**WEST SUSSEX COUNTY COUNCIL
STRATEGIC PLANNING CONSULTATION**

SUBJECT: LU/234/16/RES - Application for reserved matters relating to access, appearance, landscaping, layout and scale of the previously approved LU/63/11/. This application affects a Public Right of Way.

LOCATION: Fitzalan Link Road, Worthing Rd (A259), East Street, Littlehampton, West Sussex.

AB 30/11/16 - Mayer Brown Response to WSCC comments dated 21 November 2016.

scale	1:2000 @ A3	drawn by	OJN	checked by	AB
date	MAY 2016	cad file	PROW-01-P3.DWG		
drawing number	PHF-MB-S278-GF-DR-D-PROW-01			rev.	P3

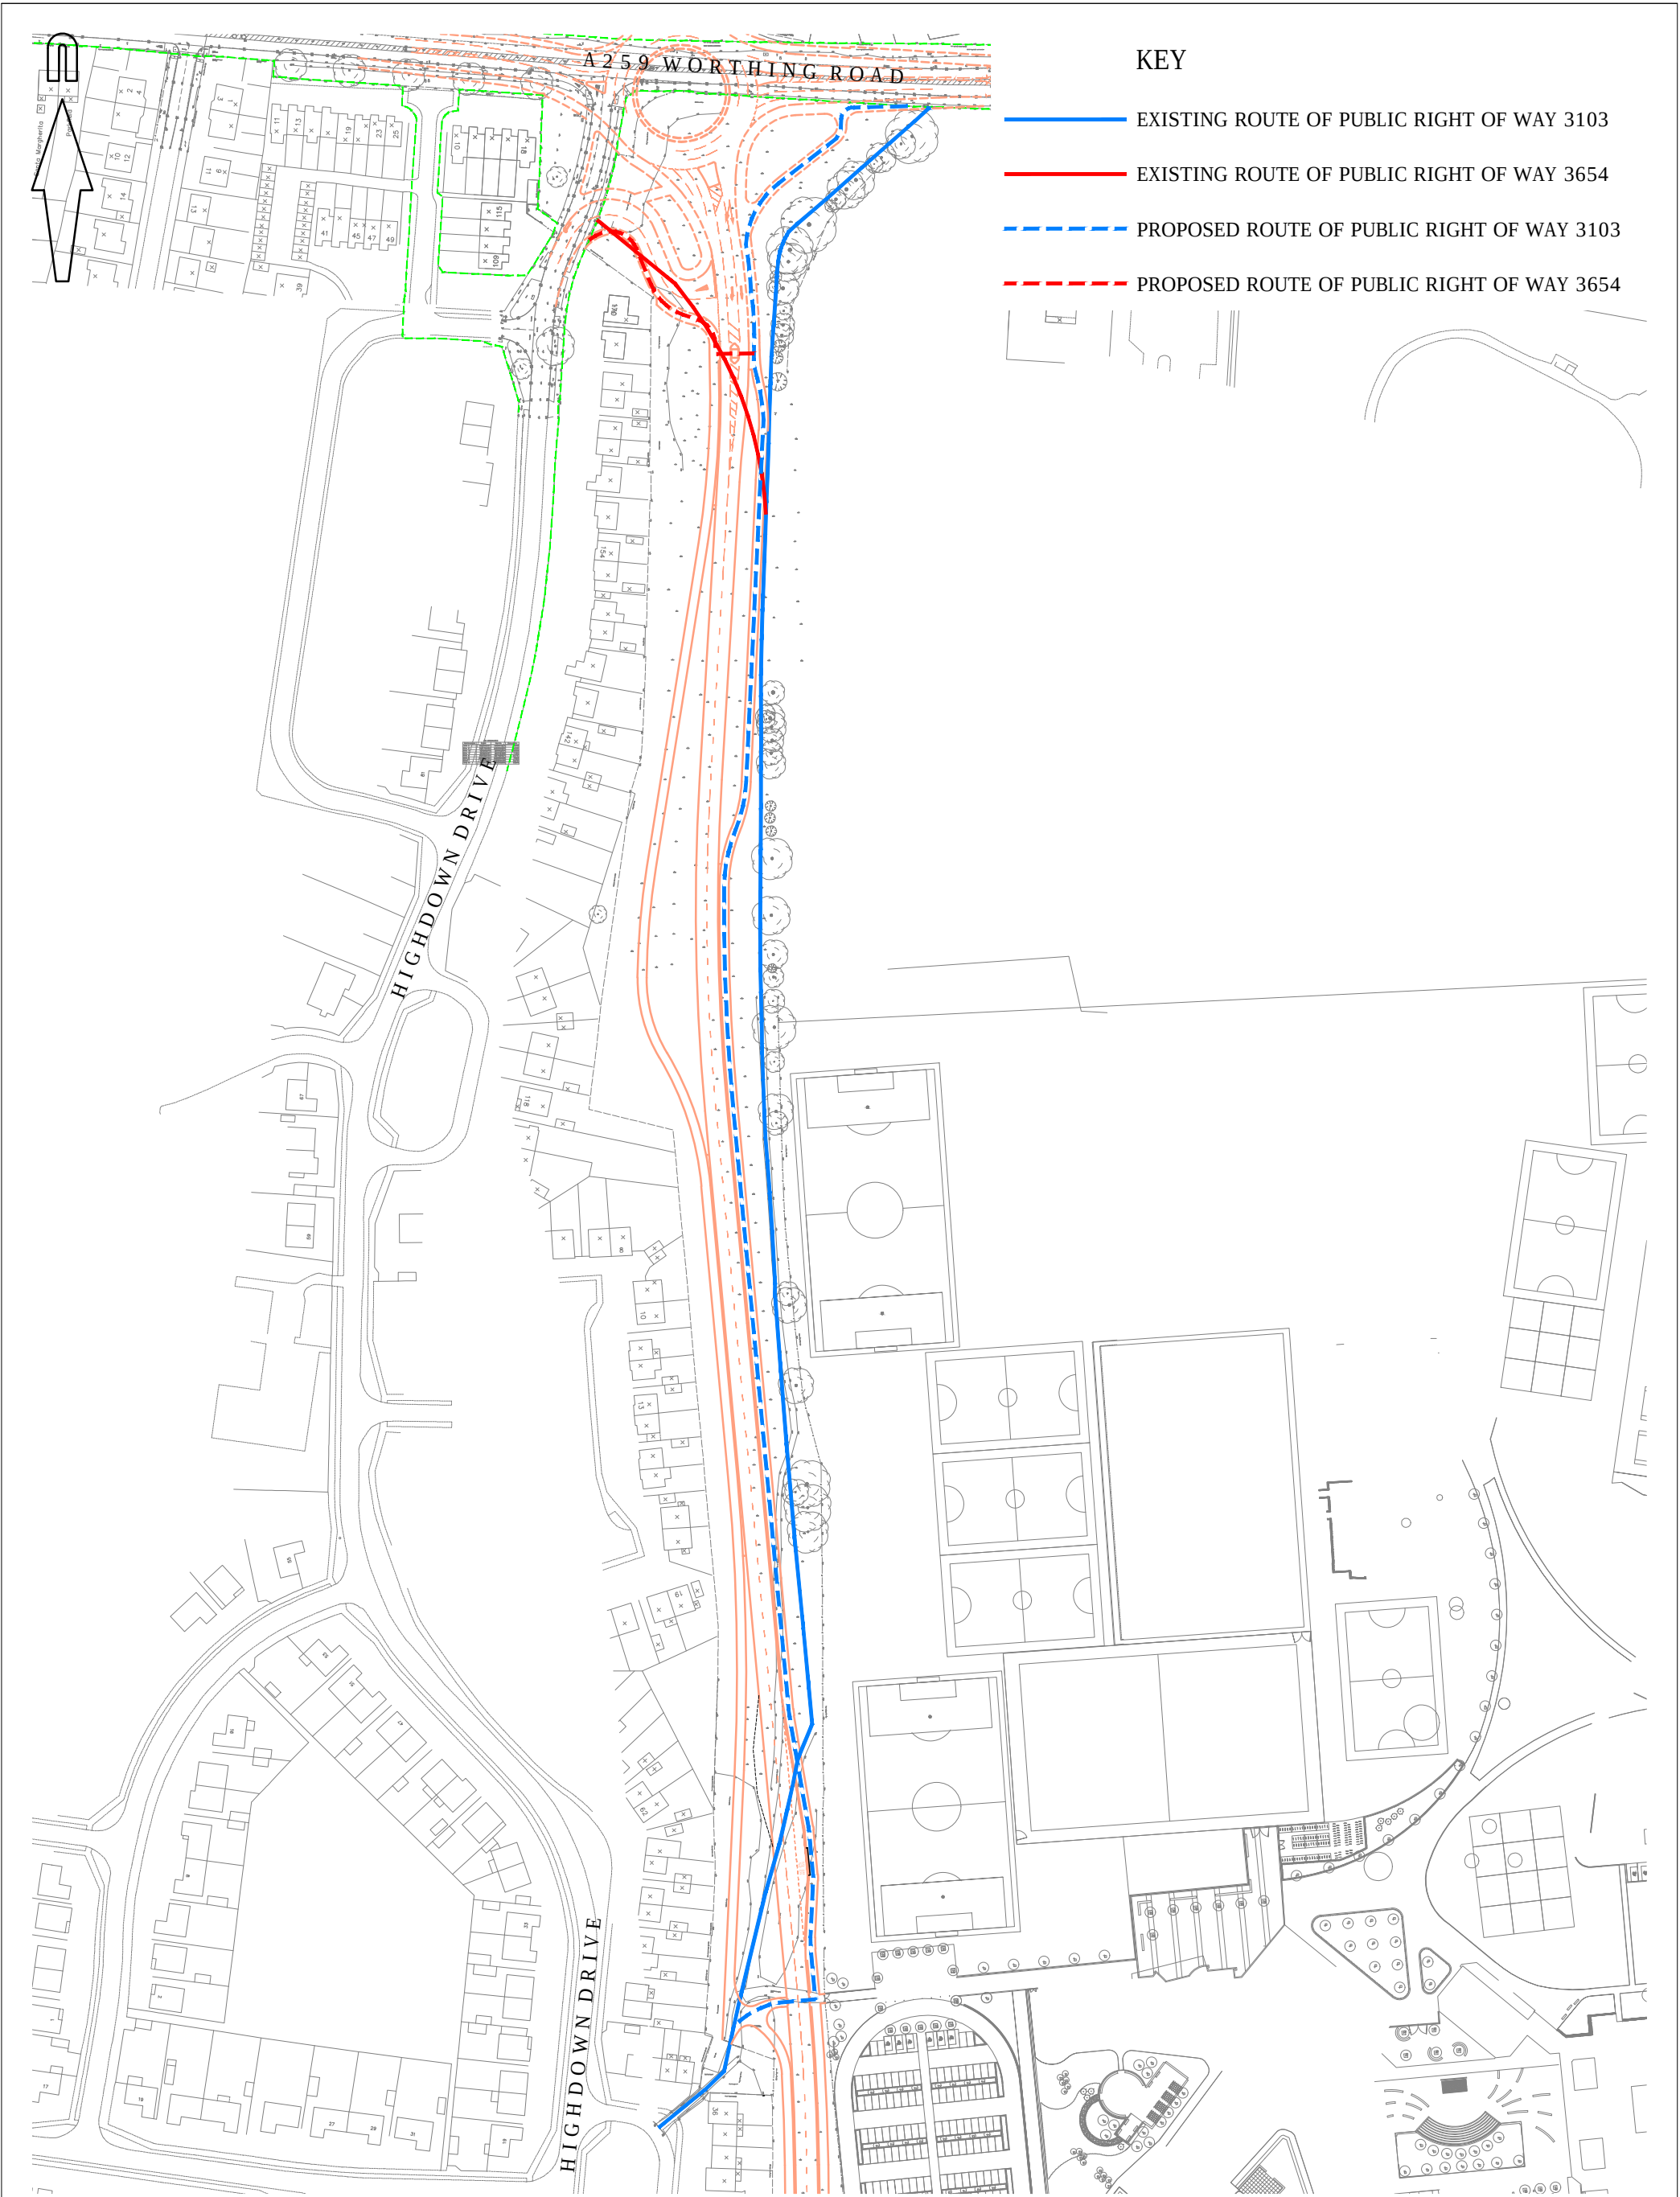
1. Red line boundary – This has implications for PRow connection in south-western corner (north of Academy roundabout) – please demonstrate that an appropriate design can be accommodated and correctly interact with existing PRow connection. As shown, the existing path and the new paths do not appear to tie-in. Also see 3 below. **Further information and alterations required.**

3. Shared footpath/cycleways alongside both sides of the access road – On the western side at the point the PRow joins the scheme, the alignment is very convoluted and may not meet appropriate design standards. Please amend and remove bends etc. This also applies to the 'kink' on the eastern side of the road found further north. Also, because of the increased speed limit along the majority of the road, it is recommended that the footpath/cycleways be set-back from the edge of the carriageway by a minimum of 1.5m wherever possible. Also because of the speed limit, a signal controlled crossing should be provided in this location (Toucan). Any design should be Safety Audited before planning consent is issued. **Please provide amendments, Road Safety Audit and Designer's Response.**

Accepted. The full extent of the land required to implement the outline consented scheme has not been made available. As a result, the alignment of the shared footway/cycleway has been altered from that indicated at Outline Consent stage. The geometry of the facility has been revised to provide a more suitable design and continuity of the PRow within the constraints of the site limits. The proposed PRow ties into the existing PRow route at the red line. Please refer to amended drawings PHF-MB-S278-GF-DR-D-210-01 Rev P5 and PHF-MB-S278-GF-DR-D-PROW-01 Rev P3.

Accepted. The full extent of the land required to implement the outline consented scheme has not been made available. As a result, the alignment of the shared footway/cycleway has been altered from that indicated at Outline Consent stage. The geometry of the facility on the western side has been revised to provide a more suitable design and continuity of the PROW within the constraints of the site limits. The proposed PROW ties into the existing PROW route at the red line. Please refer to amended drawings PHF-MB-S278-GF-DR-D-210-01 Rev P5 and PHF-MB-S278-GF-DR-D-PROW-01 Rev P3.

The geometry of the eastern facility has been amended to provide a more suitable design as requested. Please refer to amended drawings PHF-MB-S278-GF-DR-D-210-02 Rev P5 and PHF-MB-S278-GF-DR-D-PROW-01 Rev P3.
